Your Ref
EG/7/13/
Our Ref
Plan-2423
Date
11/3/13

Proposal: Re-construction of garage to side of dwelling.
Site: 4 Wandleys Drive, Eastergate PO20 3SF.
EG/7/13/

site plan

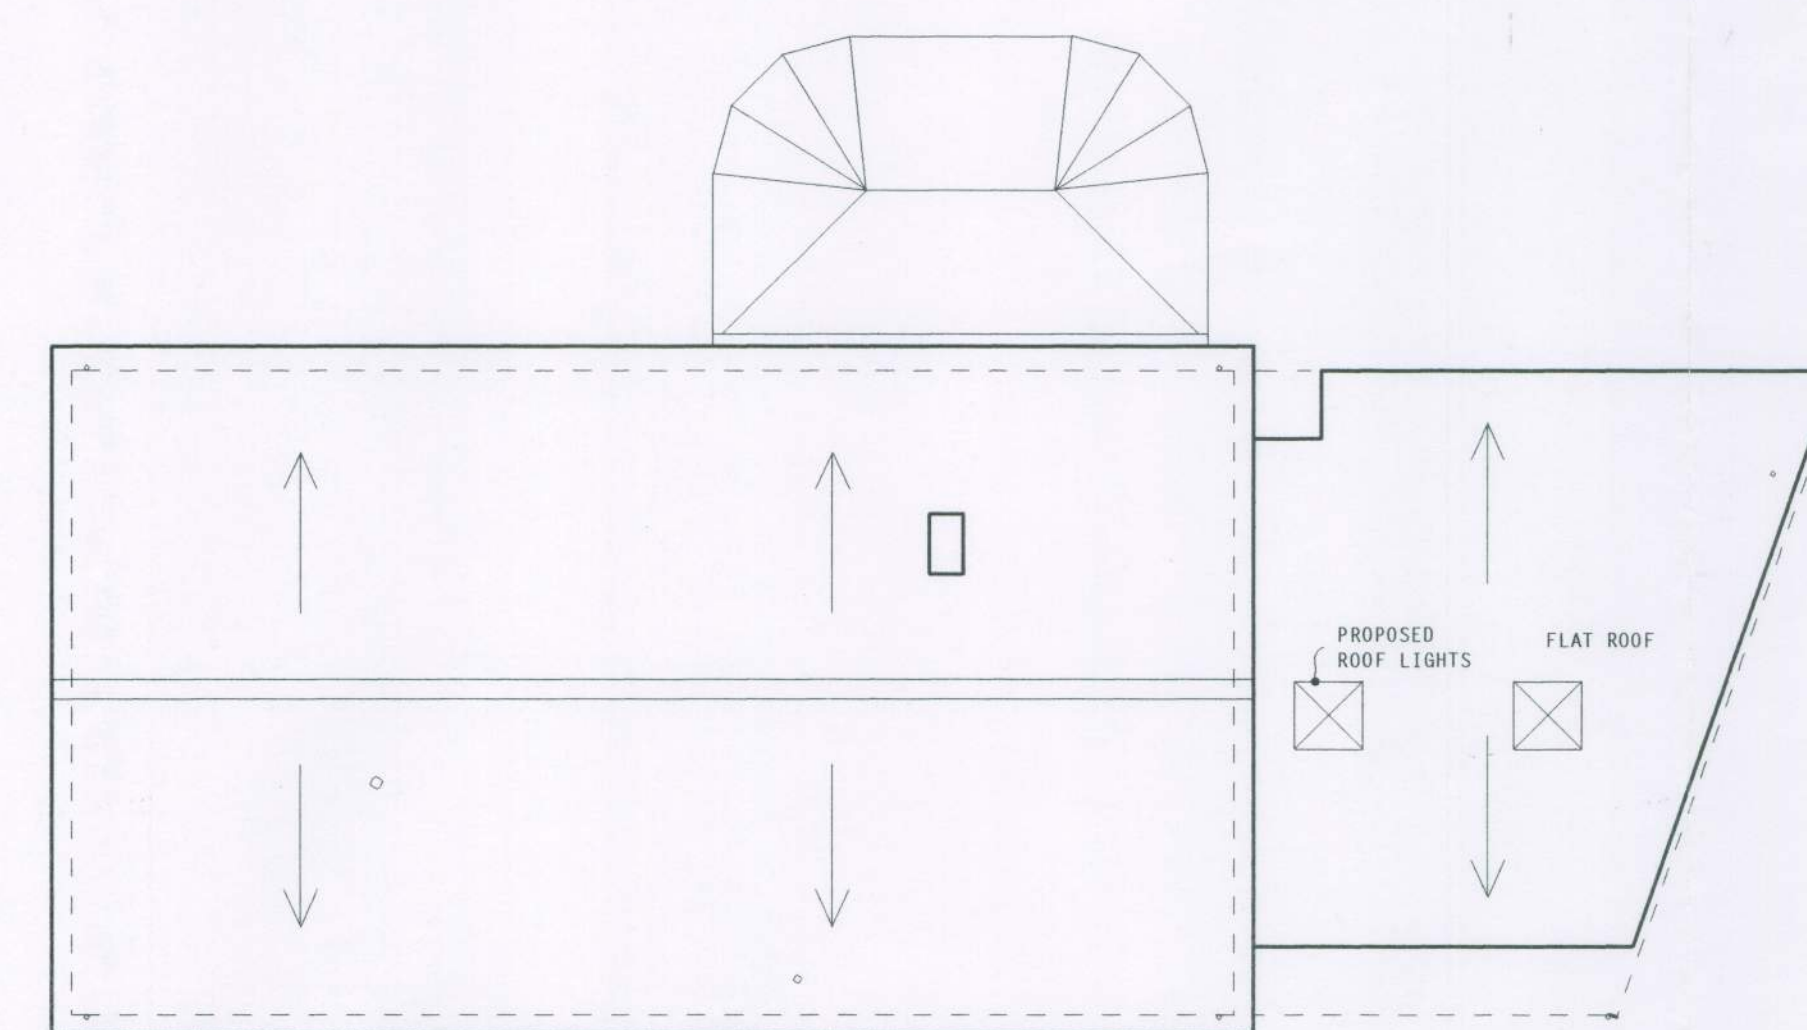
The applicant has not stated details of the proposed means of disposal of surface water from the site. Our initial investigations indicate that there are no public surface water sewers in the area to serve this development. Alternative means of draining surface water from this development are required. This should not involve disposal to a public foul sewer.
